Lime Down

Solar Park

Statement of Common Ground with Cotswolds National Landscape Board (Clean)

Planning Inspectorate Reference: EN010168

LIME DOWN SOLAR PARK
Figure 3-4-1
Lime Down Solar Park - Site A
Landscape and Ecology Mitigation Plan - Revision 3
END10168/APP/6.2
5(2)(a)

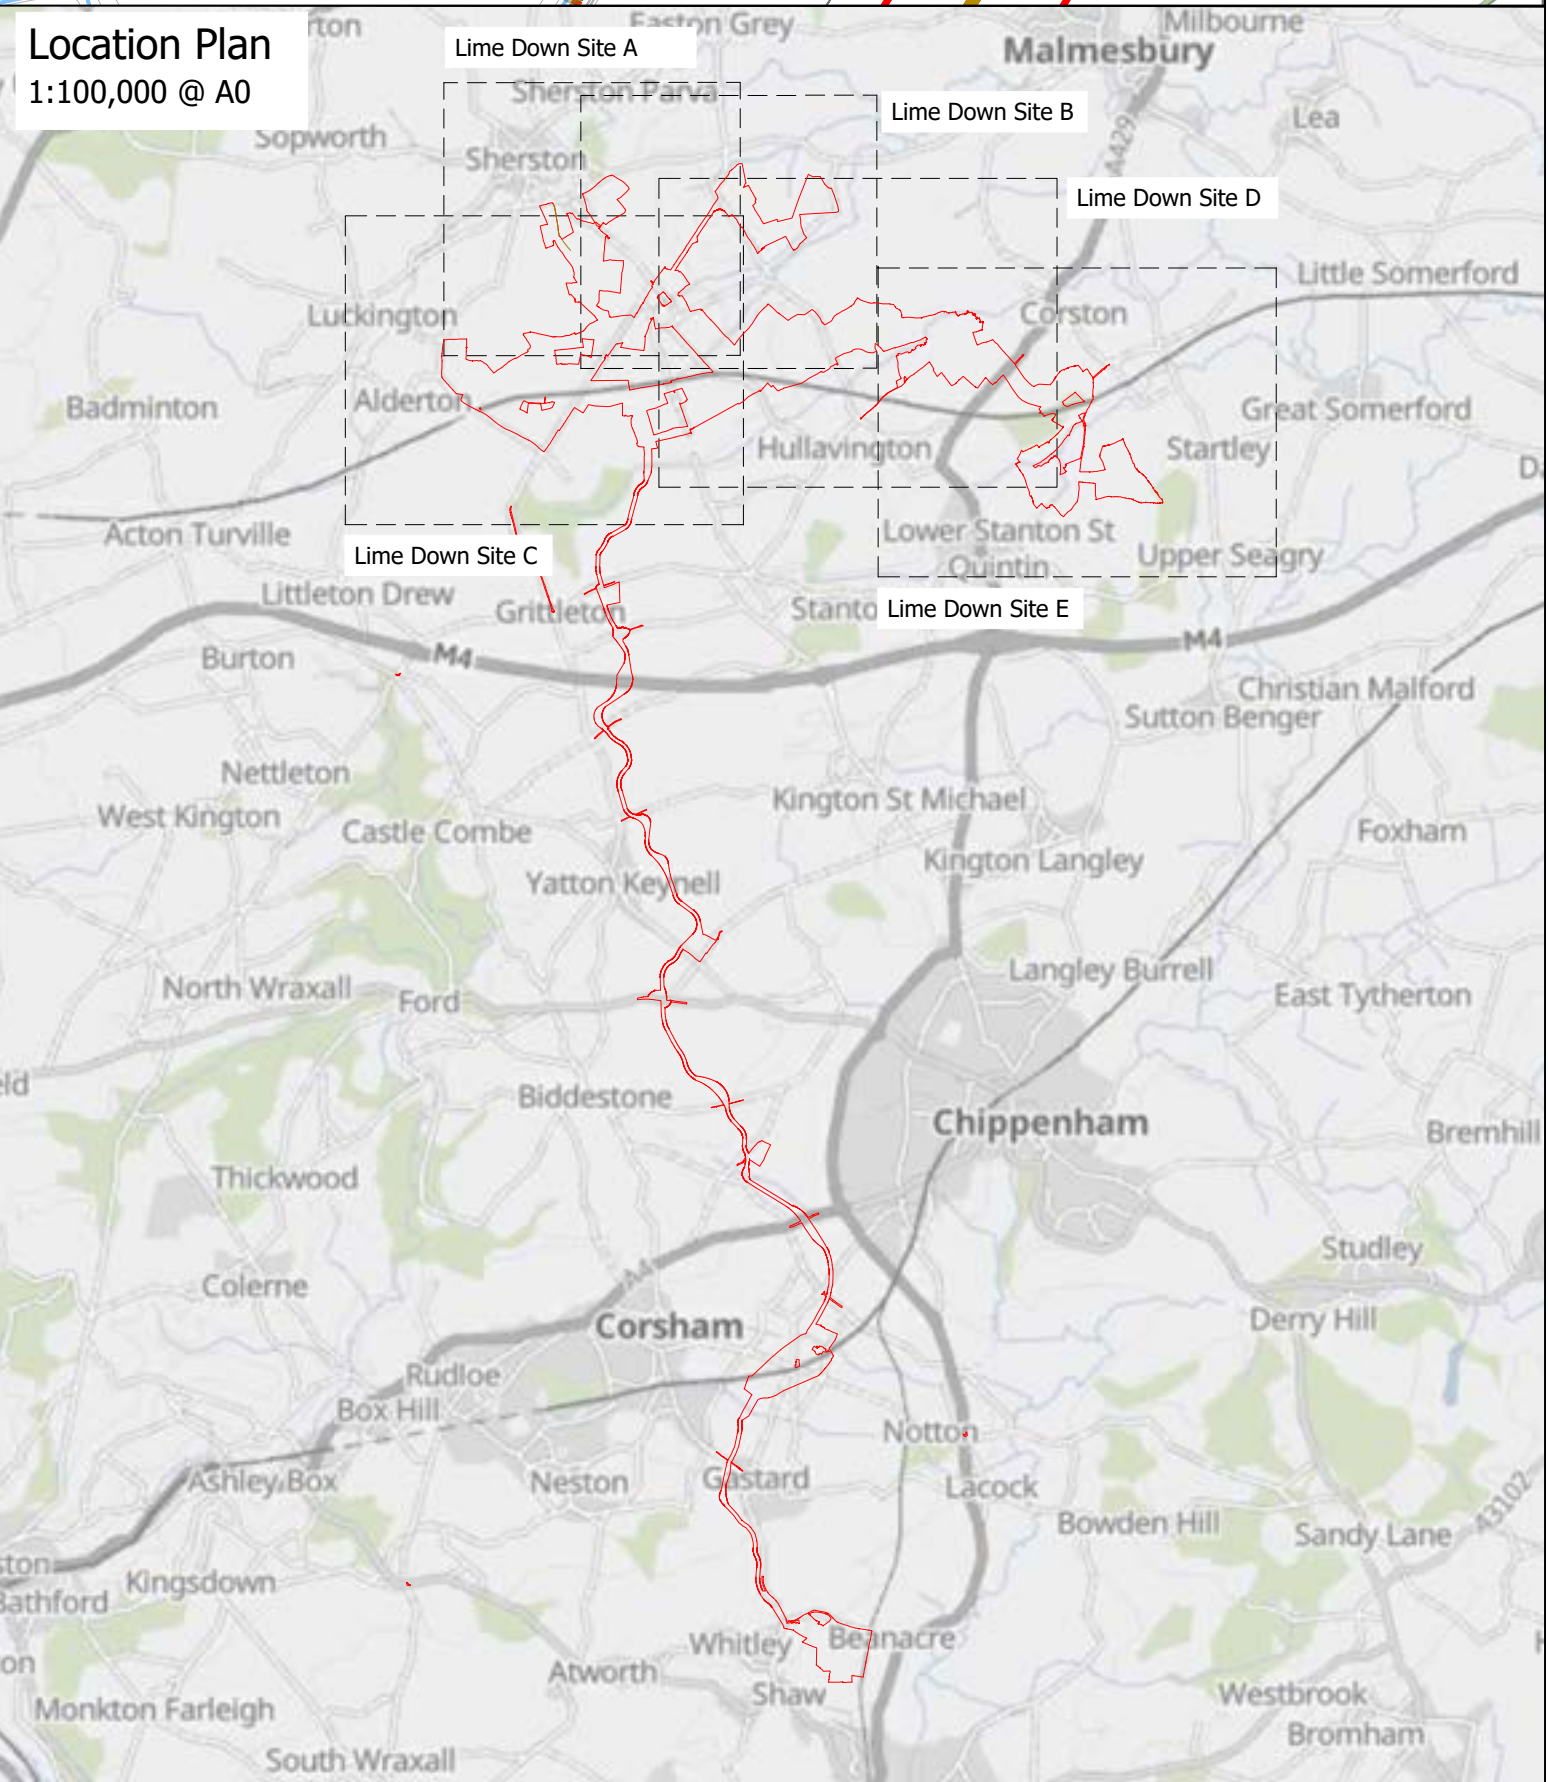
3.1.13	Embedded Design Mitigation	The CNLB awaits the submission of further information from the Applicant, notably the additional photomontages as requested within the Rule 8 letter on 24 April 2026. This will allow the CNLB to further assess the approach and likely adequacy of the embedded design mitigation.	The approach and proposals for embedded mitigation set out within Section 8.9 of ES Volume 1, Chapter 8: Landscape and Visual [APP-060], considers the landscape and visual matters associated with the Scheme as part of an iterative process, Following the mitigation hierarchy, the Scheme has been designed sensitively to avoid Significant Adverse Effects to the CNL and its setting. These measures are set out in Section 8.9 of ES Volume 1, Chapter 8: Landscape	Agreed

Reference	Sub-topic	CNLB Position	Applicant's Position	Status
			and Visual [APP-060] and ES Volume 3, Appendix 8-6: Assessment of Effects on the Cotswolds National Landscape and its Special Qualities [APP-197]. The approach and proposals for the embedded design mitigation is considered appropriate and acceptable. The Applicant has produced and submitted additional photomontages in ES Volume 2, Figure 8-14: Baseline Photography and Photomontages [EN010168/APP/6.2 (Rev 3)] at Deadline 2 showing Year 15 winter visualisations.	
-3.1.14	Outline Landscape and Ecological Management Plan (PMIE 7)	The CNLB confirm their general support for the aims, scope and content of the OLEMP. However, acknowledging that the site is located within the CNL's setting, the board has several specific recommendations for the Outline Landscape and Ecological Management Plan (OLEMP, APP-283) which can be addressed through subsequent submission of the Detailed Landscape and Ecological Mitigation Plan.	The landscape and ecological improvements are set out in the ES Volume 2, Figure 3-4-1 to 3-4-5.2: Landscape and Ecology Mitigation Plans [REP1-029 to REP1-032]. The Outline LEMP [APP 283] are considered acceptable. Following further development of the Scheme, more detailed planting plans including detail of areas of landscape mitigation, location and types of planting (species), as well as number, density and	Agreed

Reference	Sub-topic	CNLB Position	Applicant's Position	Status
			specification will be provided prior to any works commencing. The detailed landscape proposals will consist of the area and extent of the Scheme shown on ES Volume 2, Figure 3-4-1 to 3-4-5.2: Landscape and Ecology Mitigation Plans [REP1-029 to REP1-032]. The Outline LEMP [APP 283] is secured by Requirement 7 of Schedule 2 of Draft DCO [REP1-007]. Following a meeting with the CNL on 30th March 2026, it was agreed that recommendations to the Outline LEMP [APP 283] can be addressed through the subsequent submission of the detailed Landscape and Ecological Management Plan post consent as secured by Requirement 7 of Schedule 2 of Draft DCO [APP 016]. Detailed versions of the Outline LEMP [APP 283] will be prepared in consultation with stakeholders, with express reference to the CNL Board as a stakeholder for aspects of the Outline LEMP [APP 283] relevant to the CNL and its setting.
